TELOPEA SSDA DPE RFI

SOLAR AMENITY REPORT [REV A]

30/05/2023

BUILDING C: L05 - 08 BEFORE

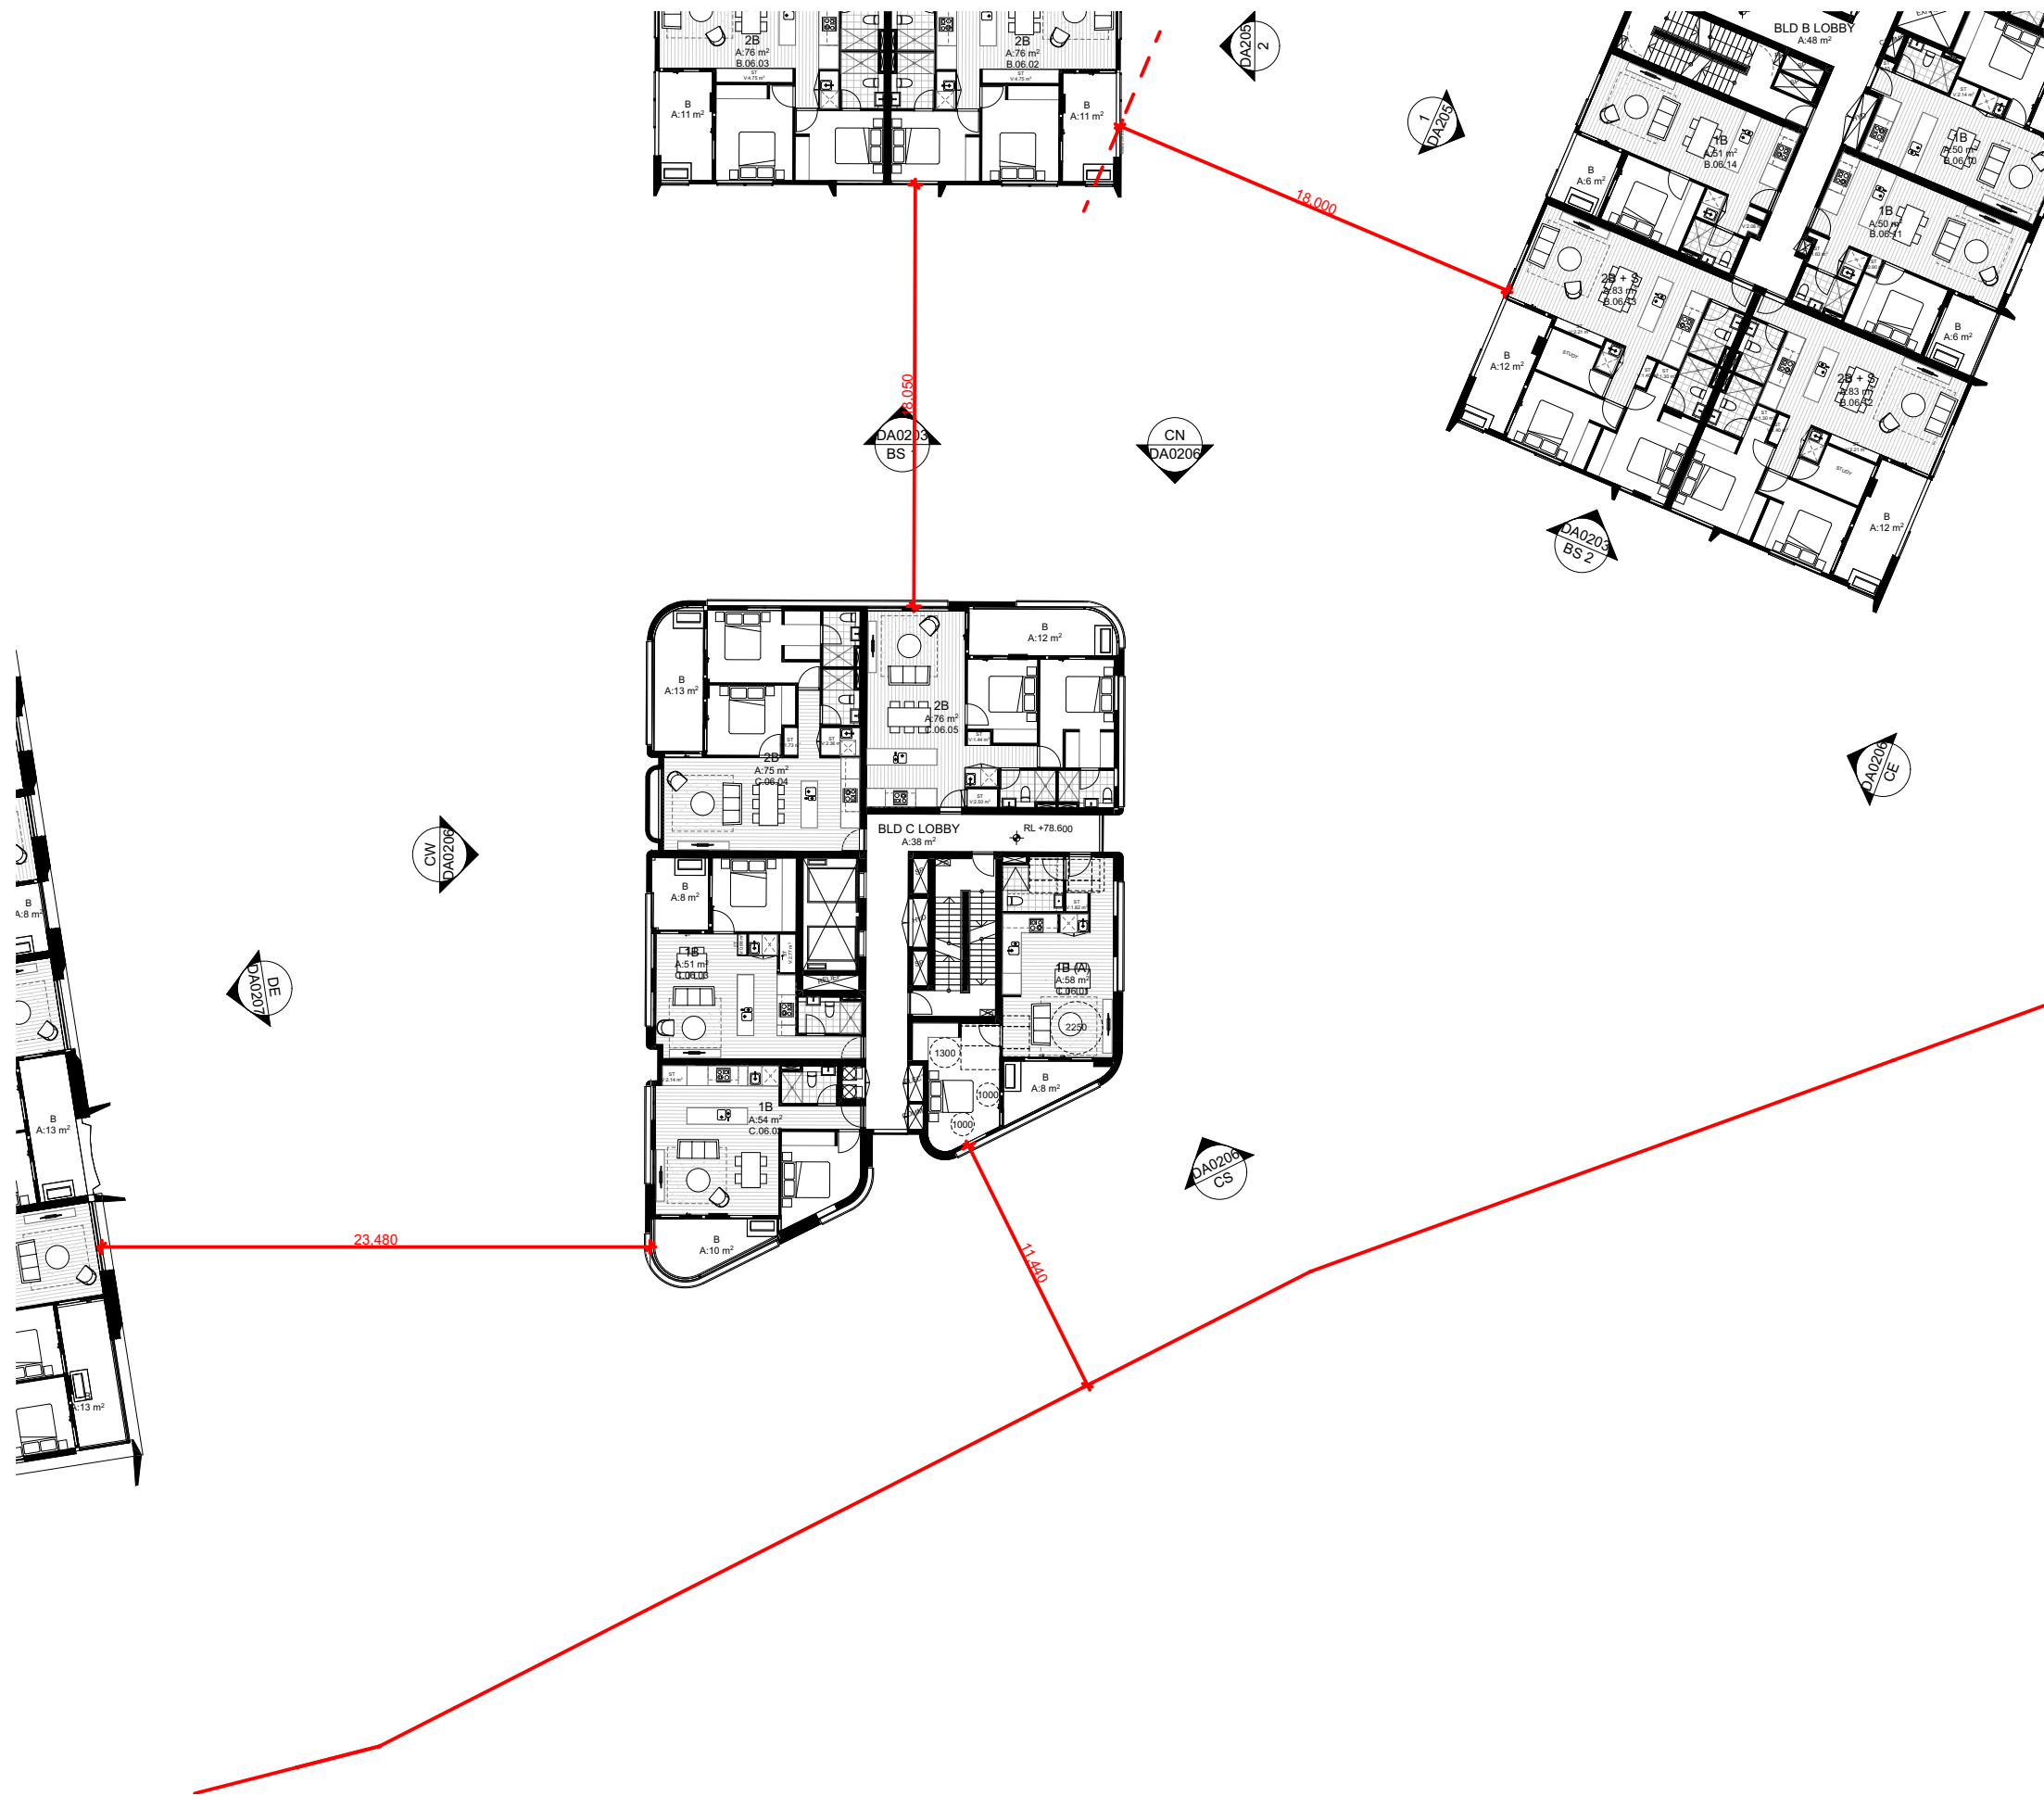
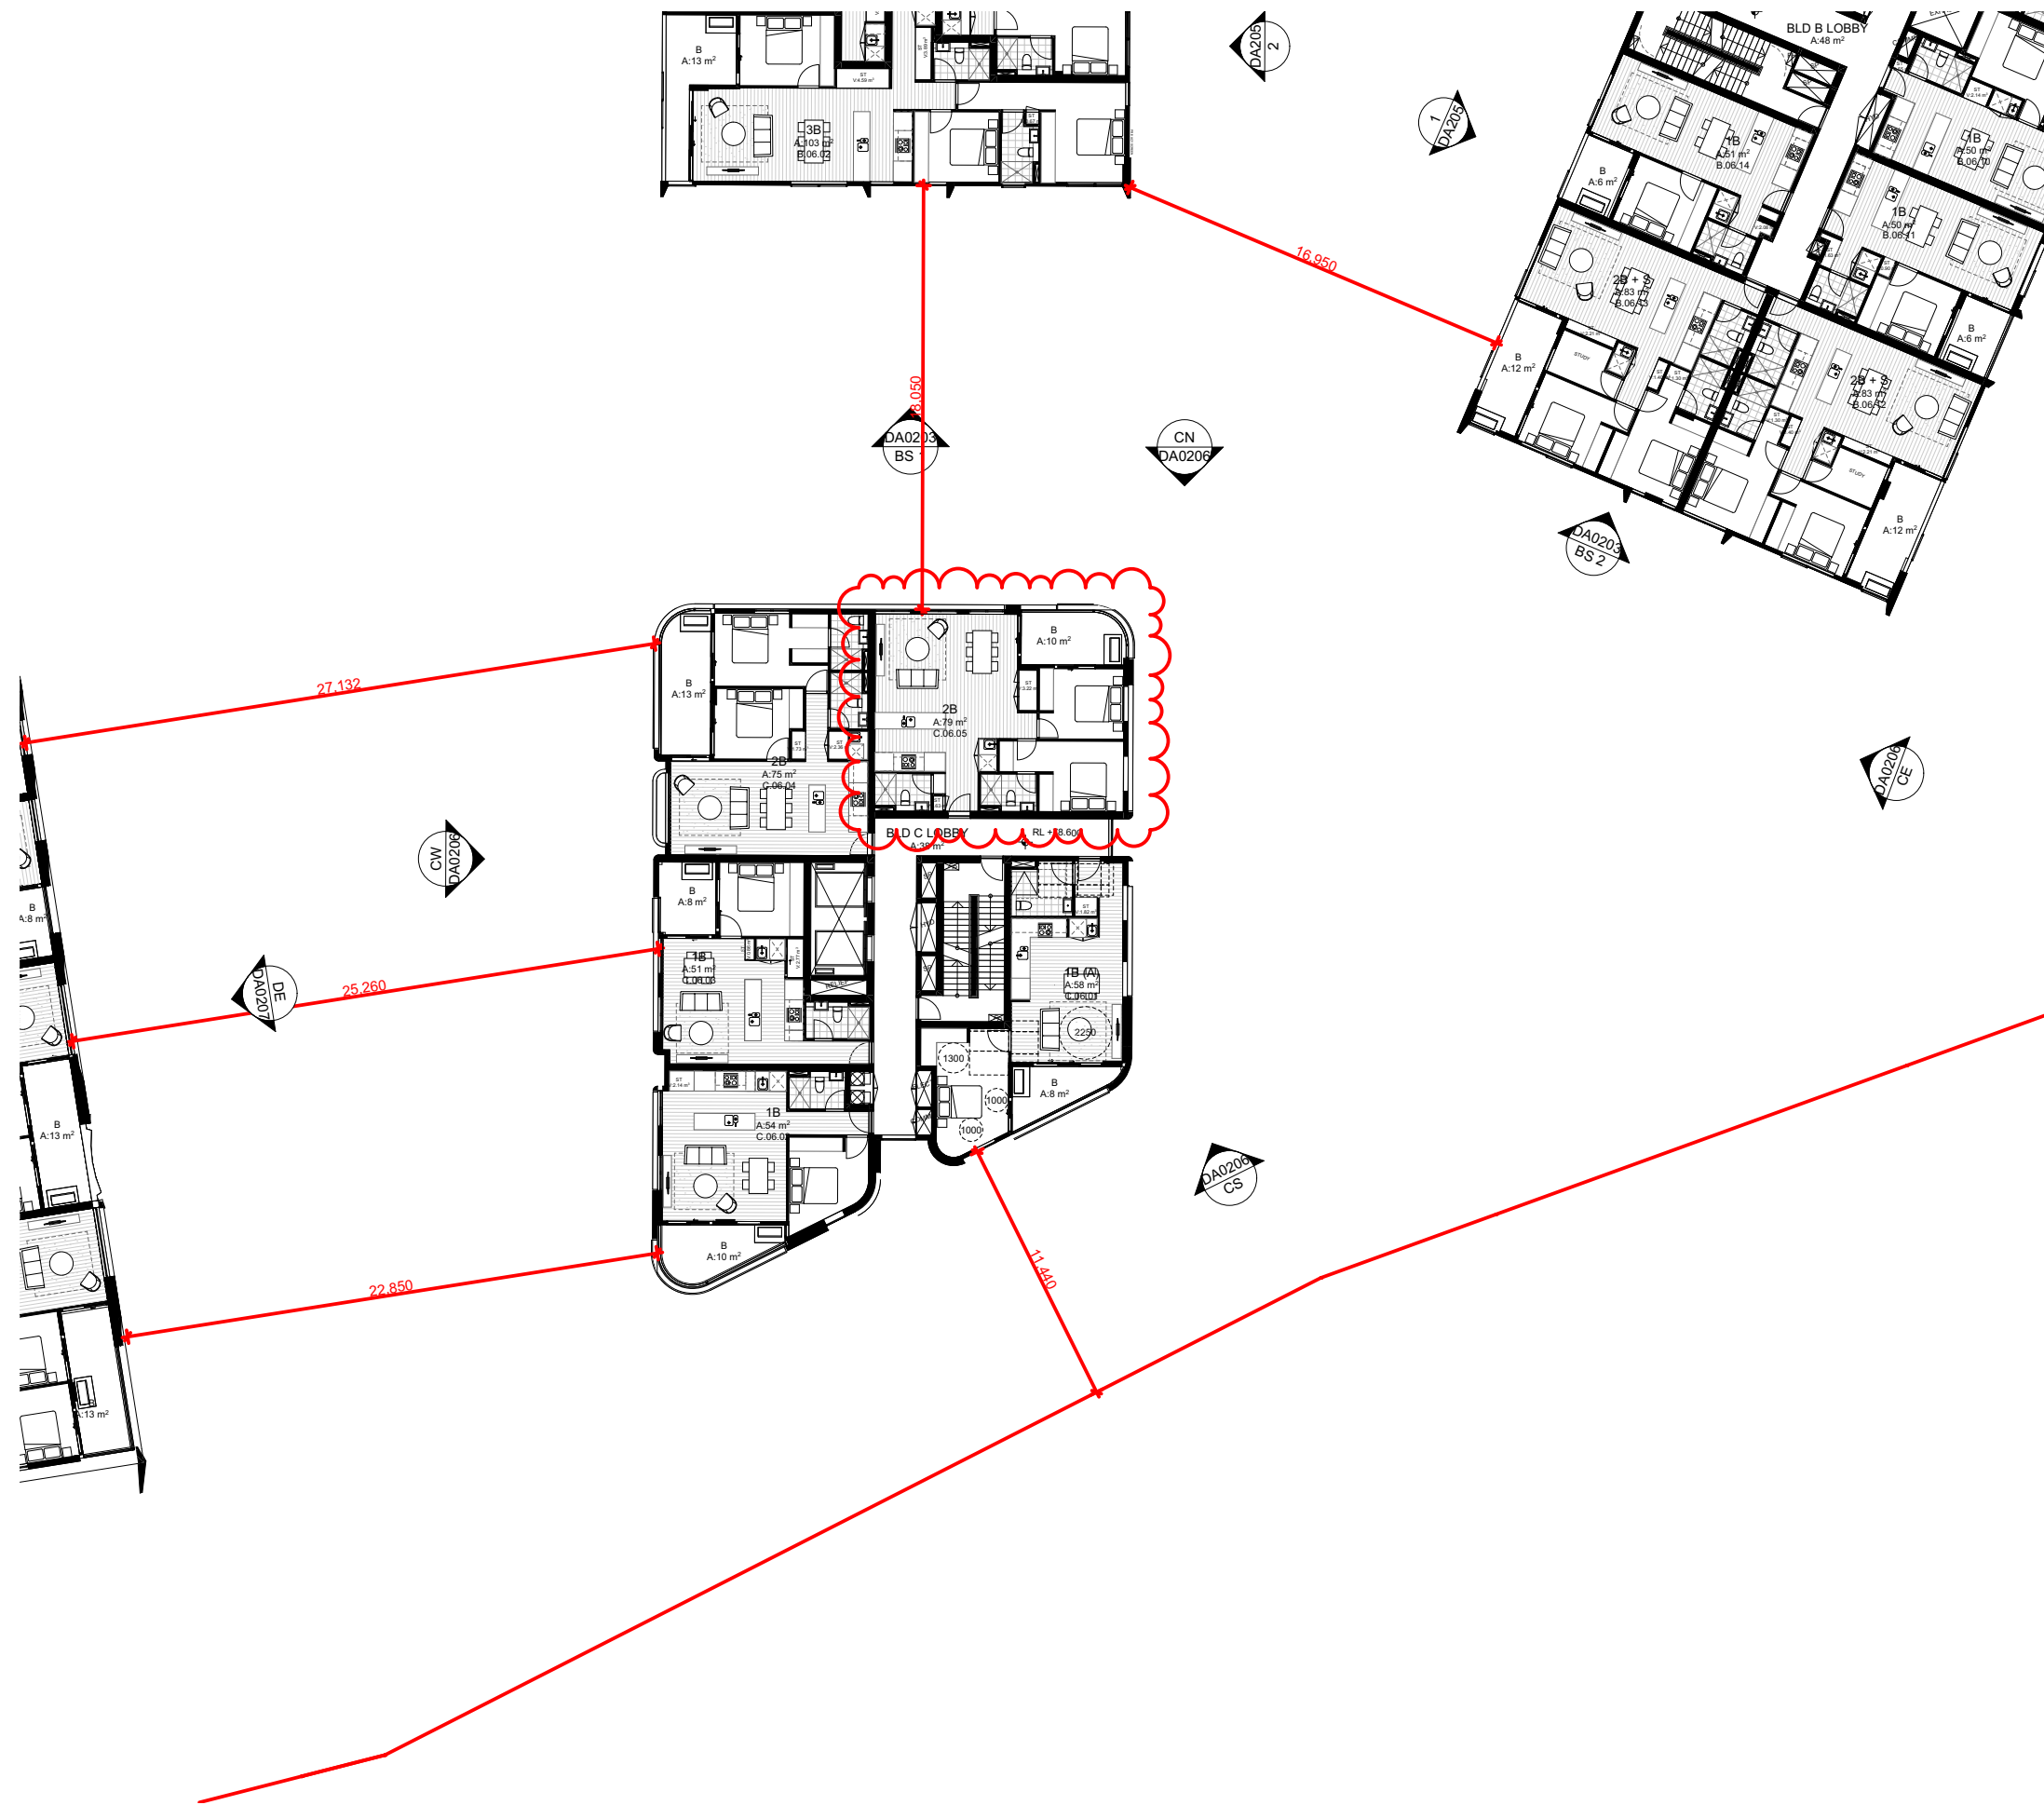
Amendments made to facades, eaves and window arrangements between L04 - L08 to improve solar access.

Minor layout amendment to C.UG.06.
Skylight added to unit C.08.01 improve solar access.

Amendments made to layout of unit 5 between L05 – L08 to improve solar access in the morning.
Minor Layout changes to -
C.05.05, C.06.05, C.07.05, C.08.05.

BUILDING E: L02-L07 BEFORE
(FACADES ALTERNATE ON EACH FLOOR)

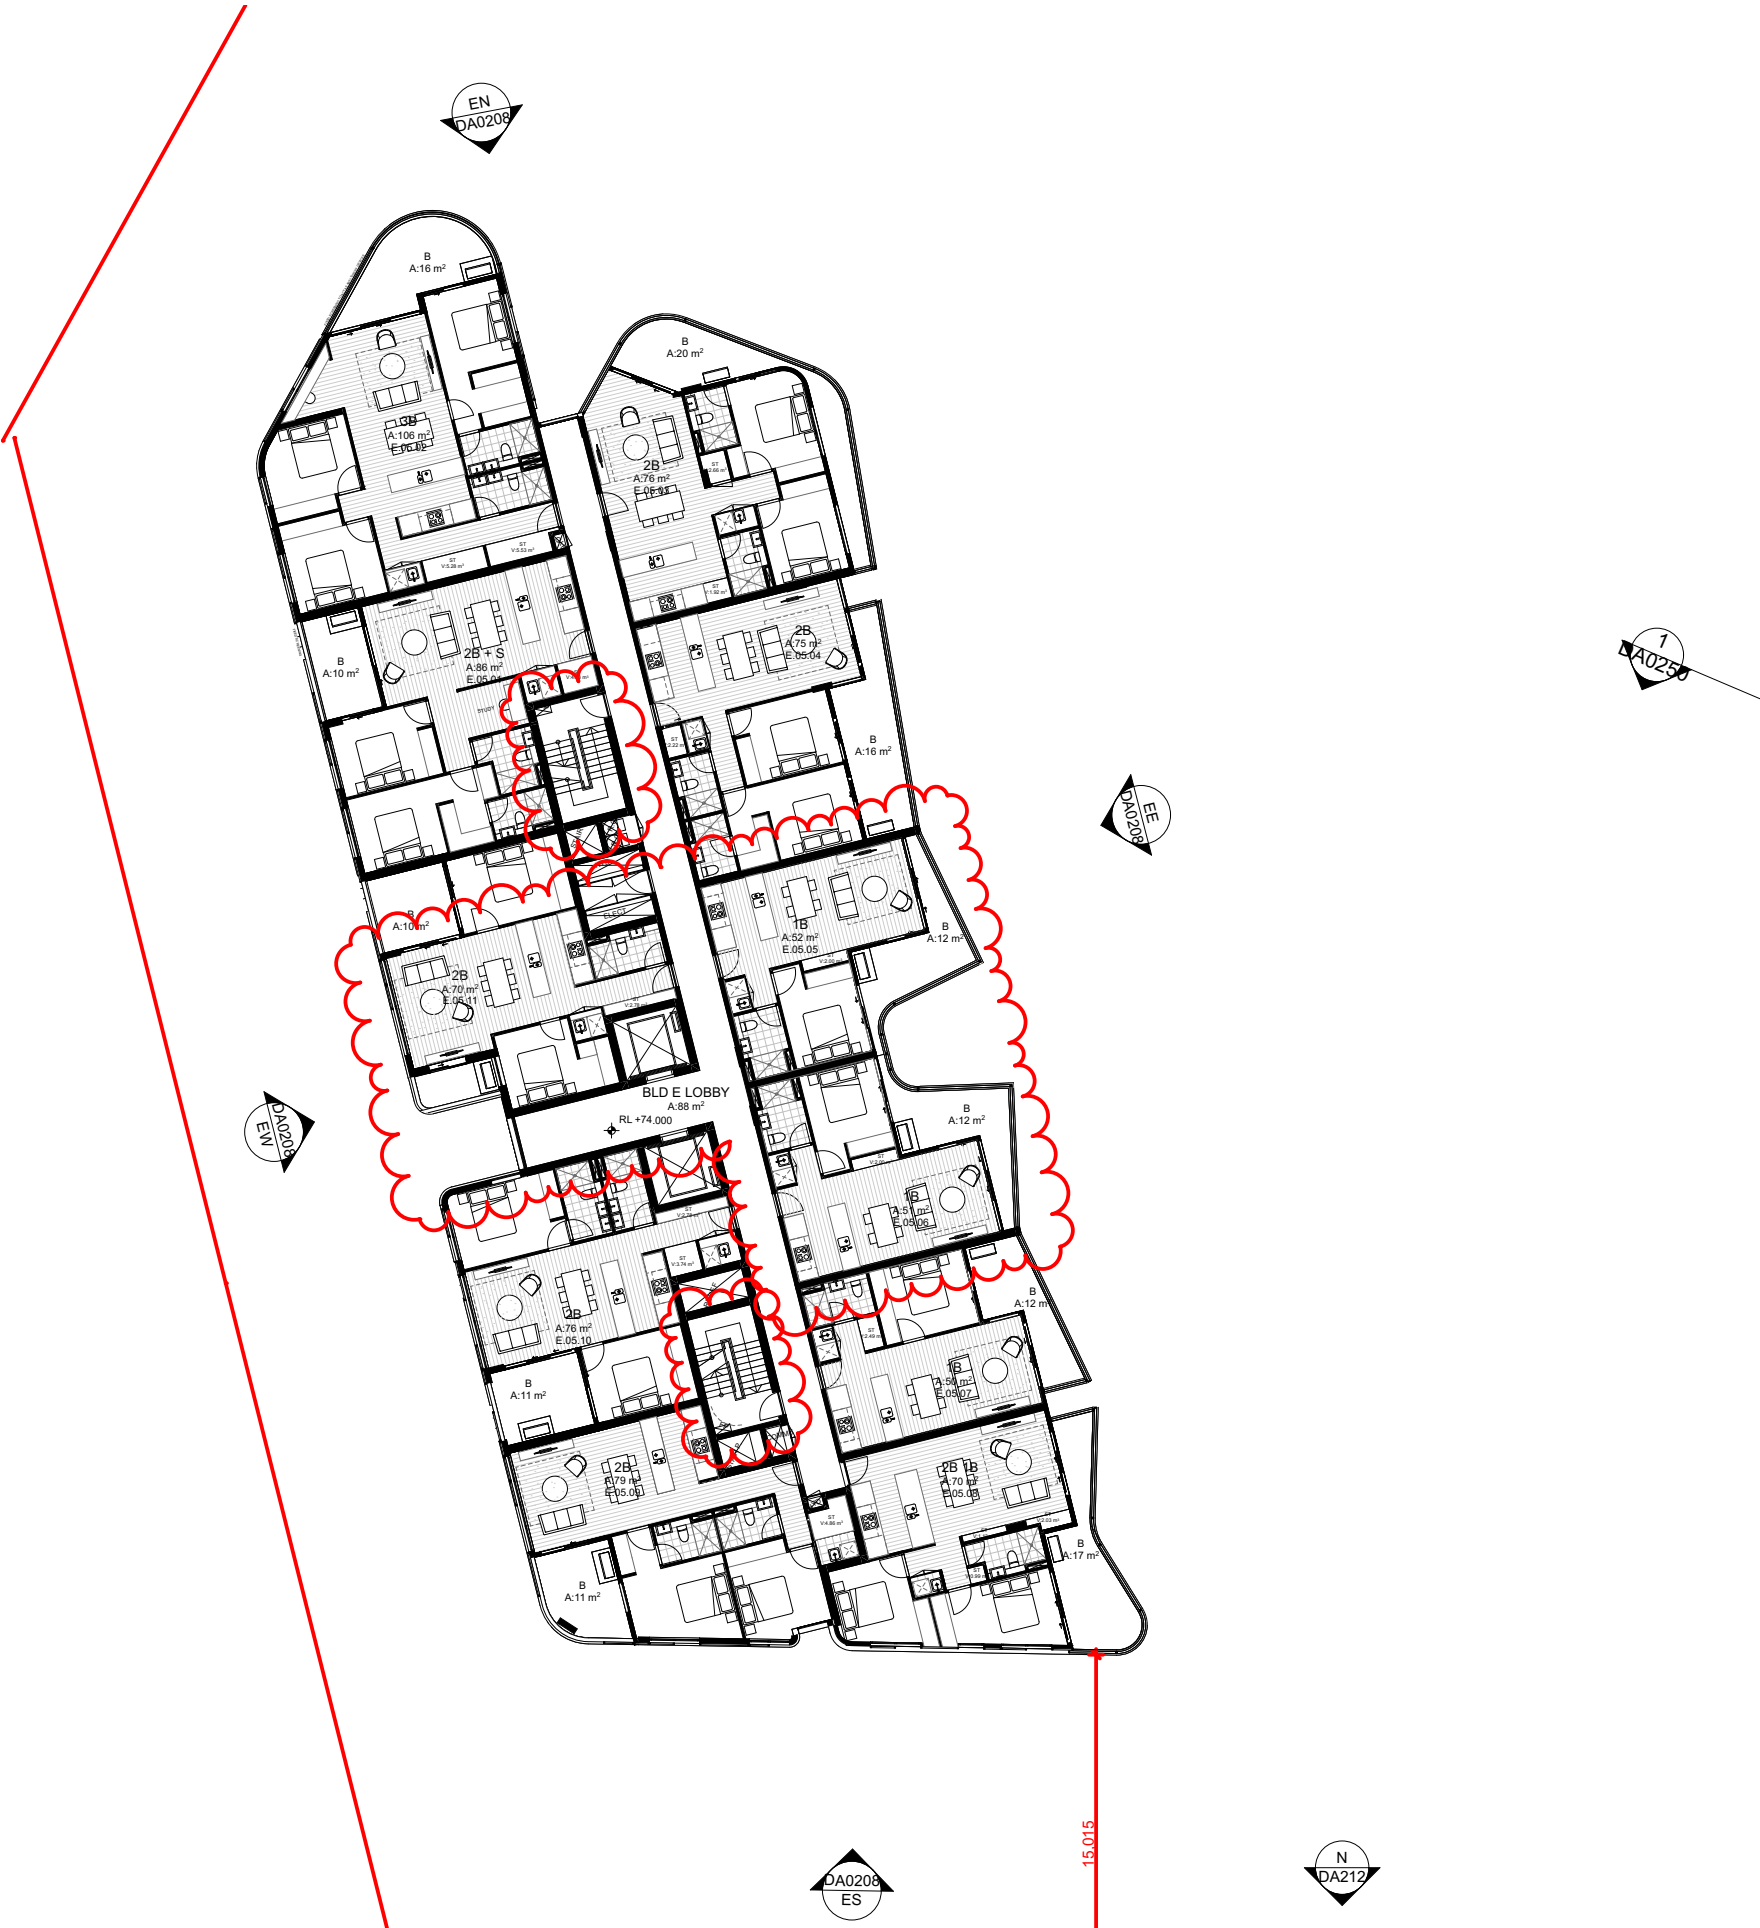
Amendments made to facades, eaves and window arrangements.
Reduction in balcony extents to improve solar access.

Amendments to the layout of some units between level LG - L07 to improve solar access in the afternoon.

Layout change to -
E.LG.05, E.UG.01, E.01.01, E.02.01, E.03.01, E.04.01, E.05.01, E.06.01, E.07.01,
